OFFICIAL NOTICE OF DECISION

Project# PR-2020-004171
Application#
MAJOR_PLT-2025-00011 AMENDMENT TO
PRELIMINARY PLAT

For all or a portion of:
Lot/Tract N7A1, TANOAN PROPERTIES
zoned **R-1D**, located at **12300 SAN**
ANTONIO DRIVE NE between TENNYSON
& LOWELL containing approximately **6.653**
acre(s). (**E-22**)

4 OF 5 3201 4th. STREET NW, SUITE C, ALBUQUERQUE, NM 87107 ww.fierrocompany.com

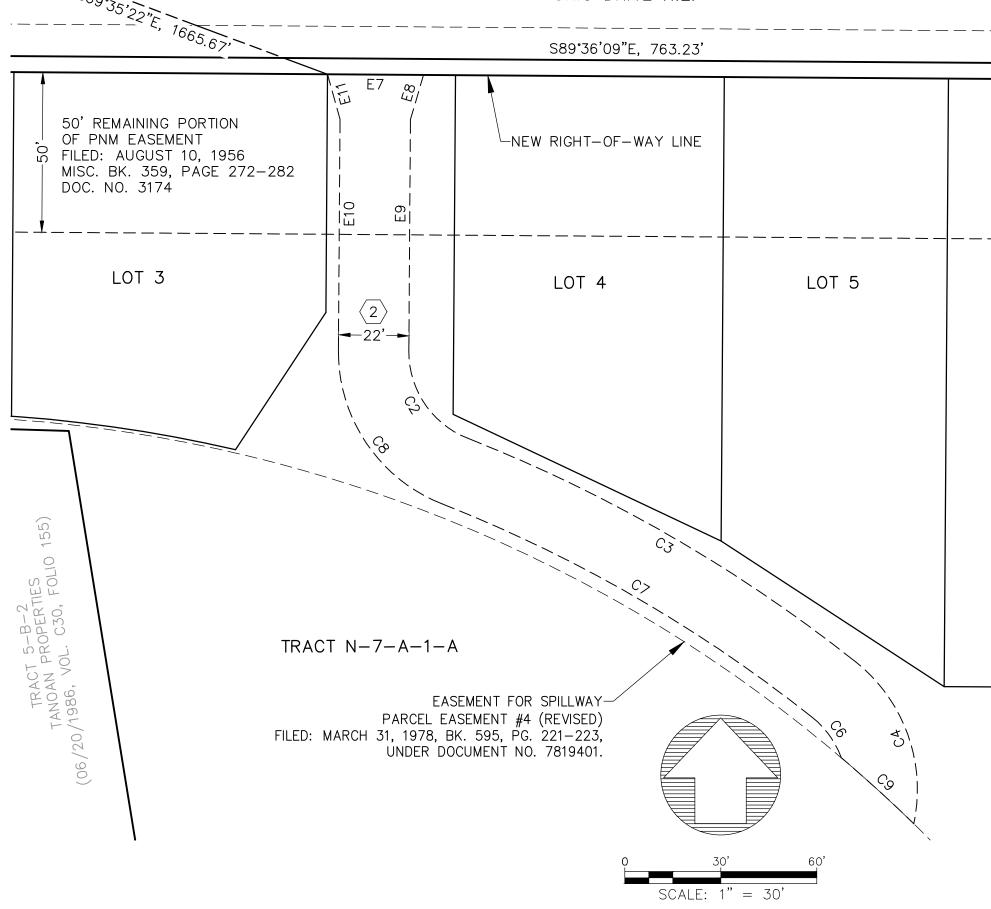
- a. On Sheet 4 of 5 please fix the leader for easement 3 to be placed on the easement instead of the property boundary as currently shown.
